Report to Wollstonecraft Precinct St Leonards Crows Nest Final 2036 Plan and Crows Nest Over Station Development (SSD-9579)

Purpose: The purpose of this report is to provide:

Part B: Crows Nest Over Station Development (SSD-9579)

5.0 SEPP 65 Analysis
5.3 Shadow Analysis
June 11:00AM - 11:30AM

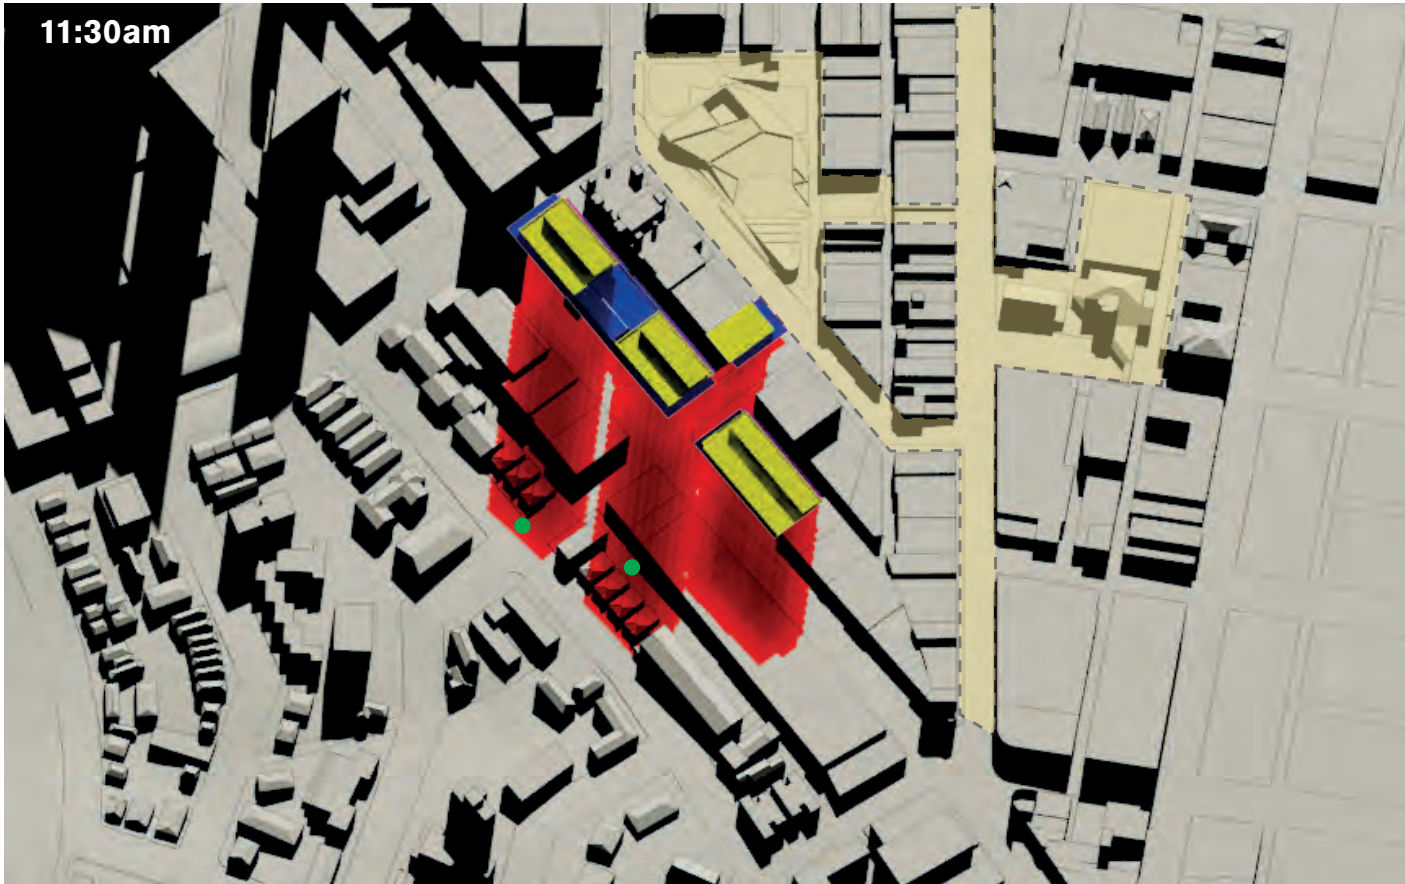
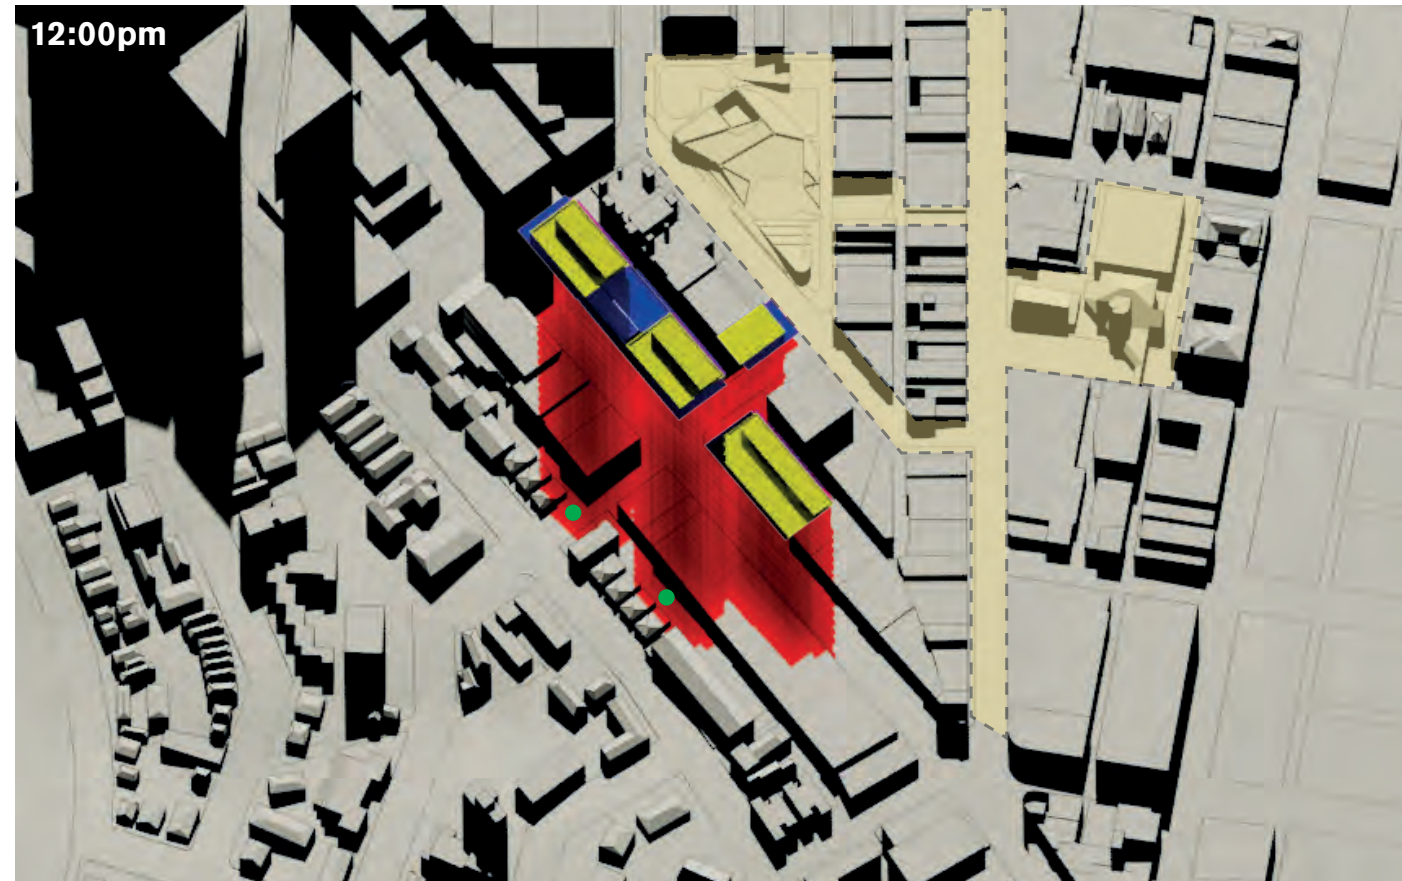
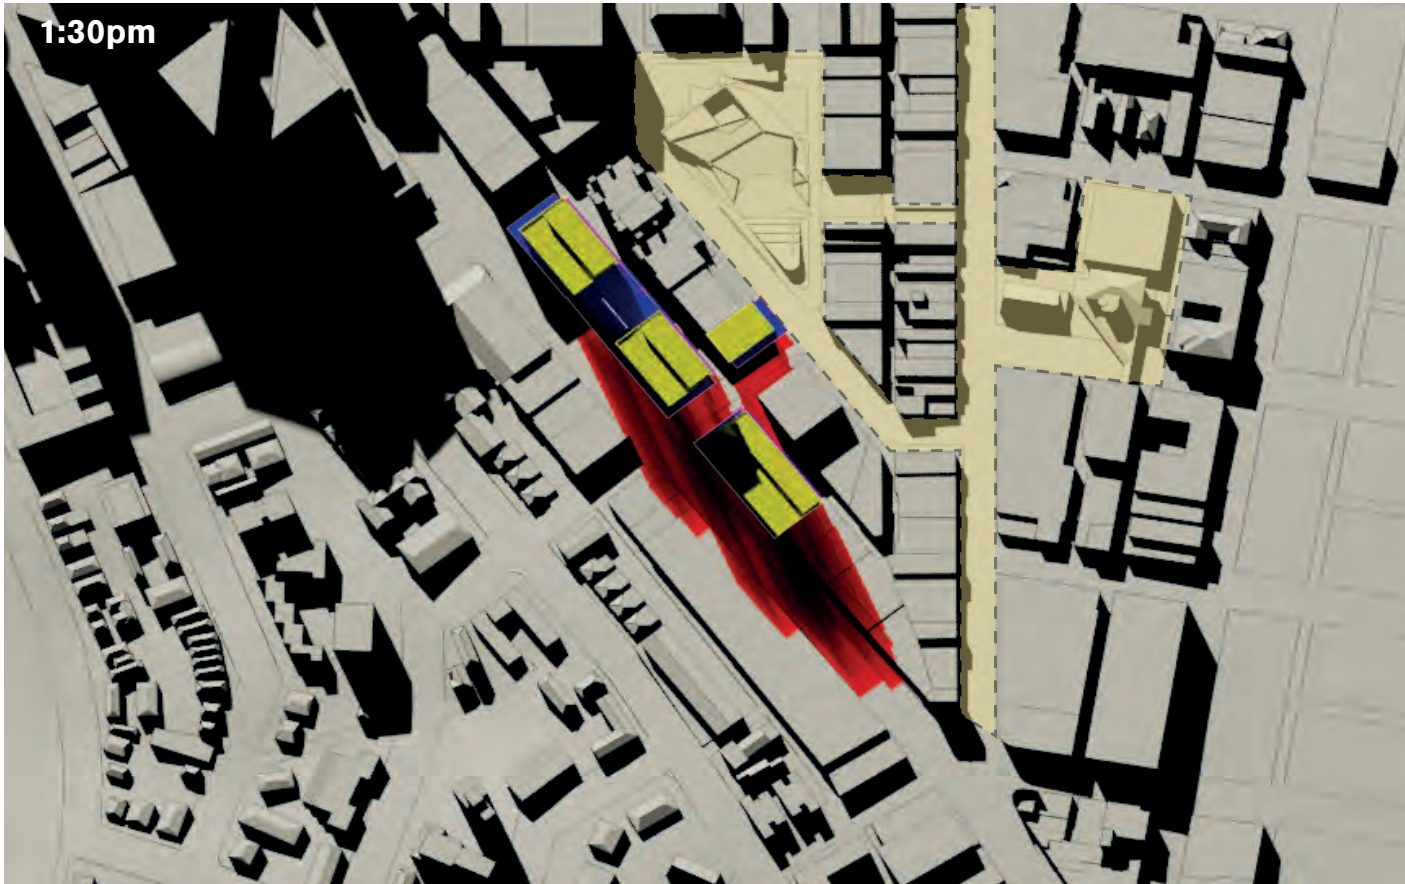
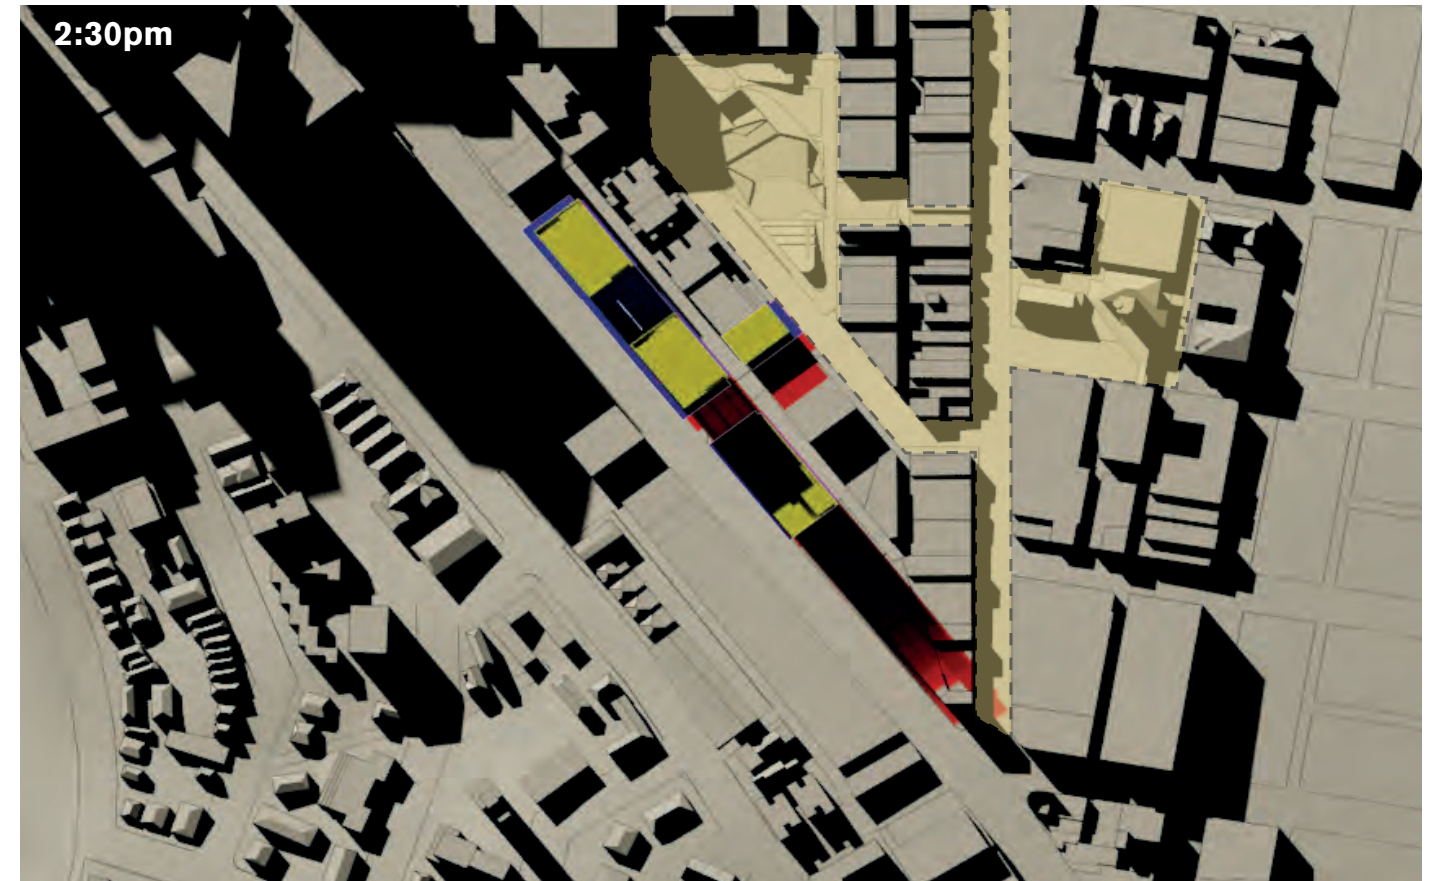
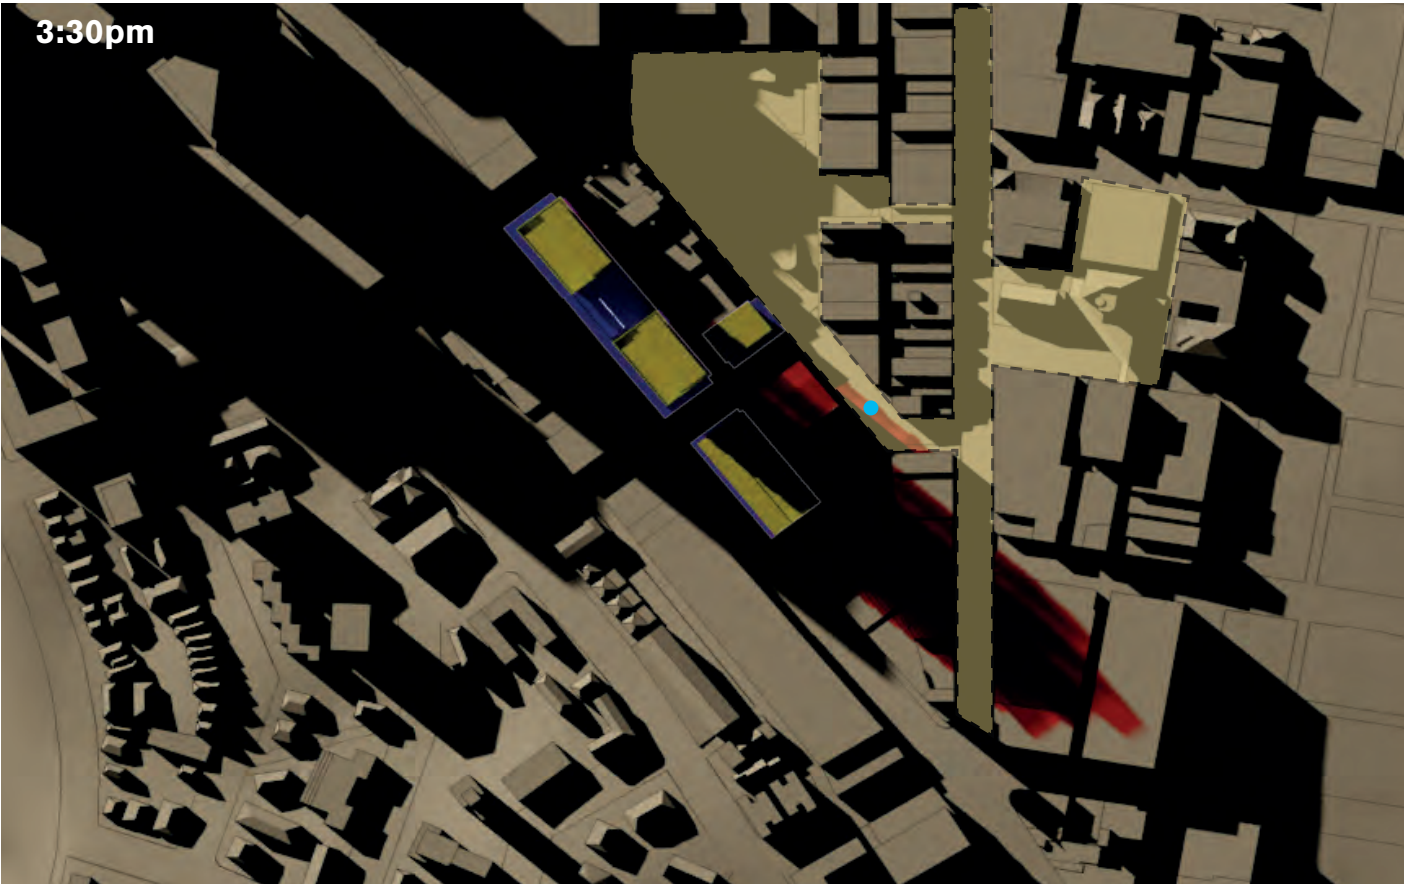
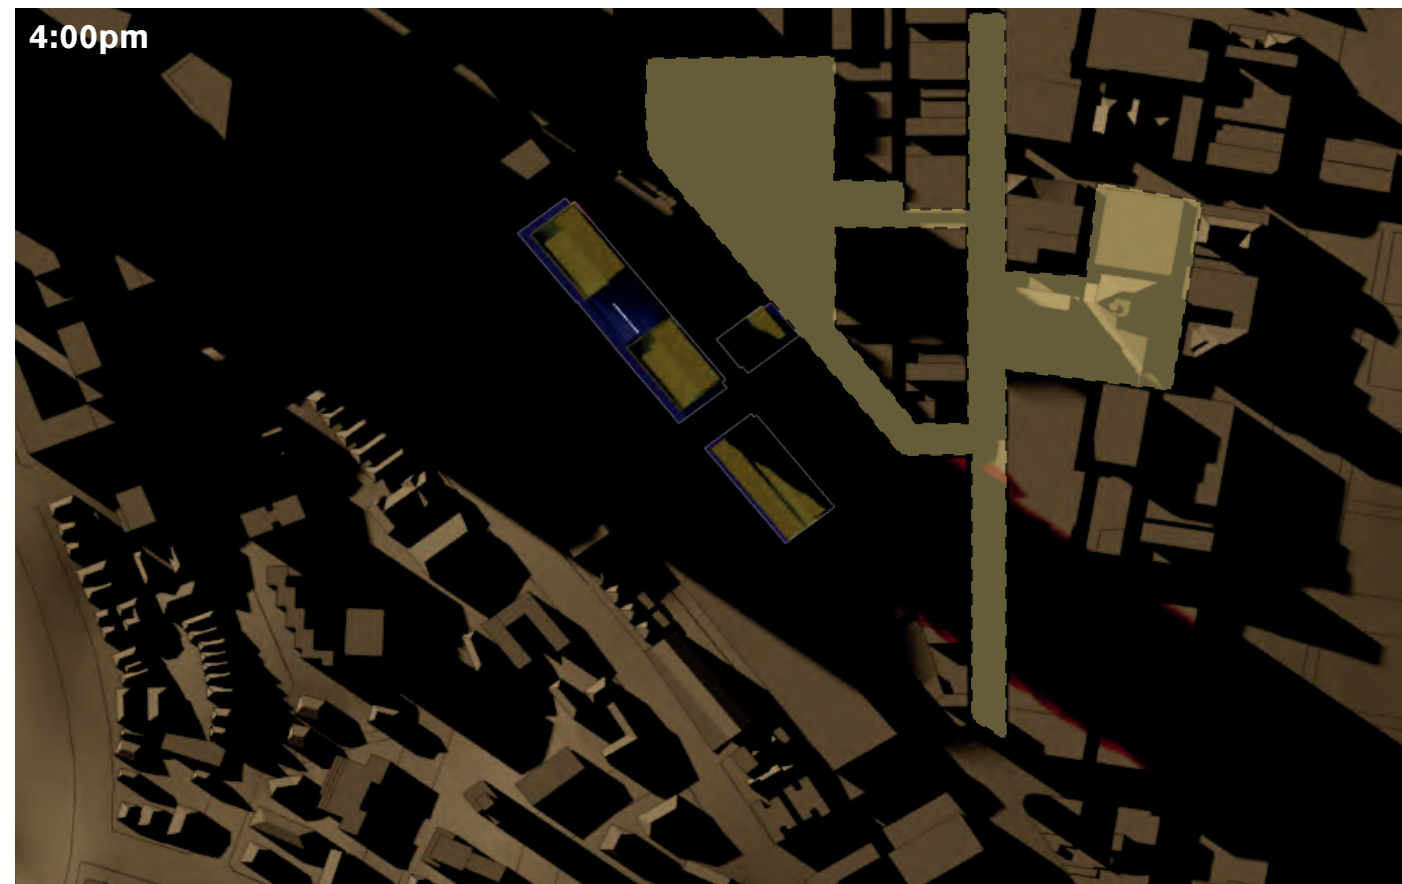
Regrettably, solar access in Crows Nest village and East Wollstonecraft is severely compromised by the plan. Transitions are no such thing; they are cliffs which demonstrates that the peak at Crows Nest remains far too high. The precedent set at St Leonards is not a justification to do the same at Crows Nest.

- a. **Road Upgrades:** The five initiatives are a small step in the right direction but only partly address the current population and traffic density. It is not enough to calm and cope with the additional traffic generated by an influx of 11,000 more people.
- b. **Heritage and Local Character.** The community made strong comments about protection of the village of Crows Nest (not just Willoughby Road) and also East Wollstonecraft which need solar access protection. The DPIE ignored these comments. The tall buildings over the station and opposite on the Highway will cast long shadows over the village west of Willoughby Road and over the low

rise residential area of East Wollstonecraft, blocking out sky views and creating wind tunnels that help destroy the fine grain nature of that part of the village.
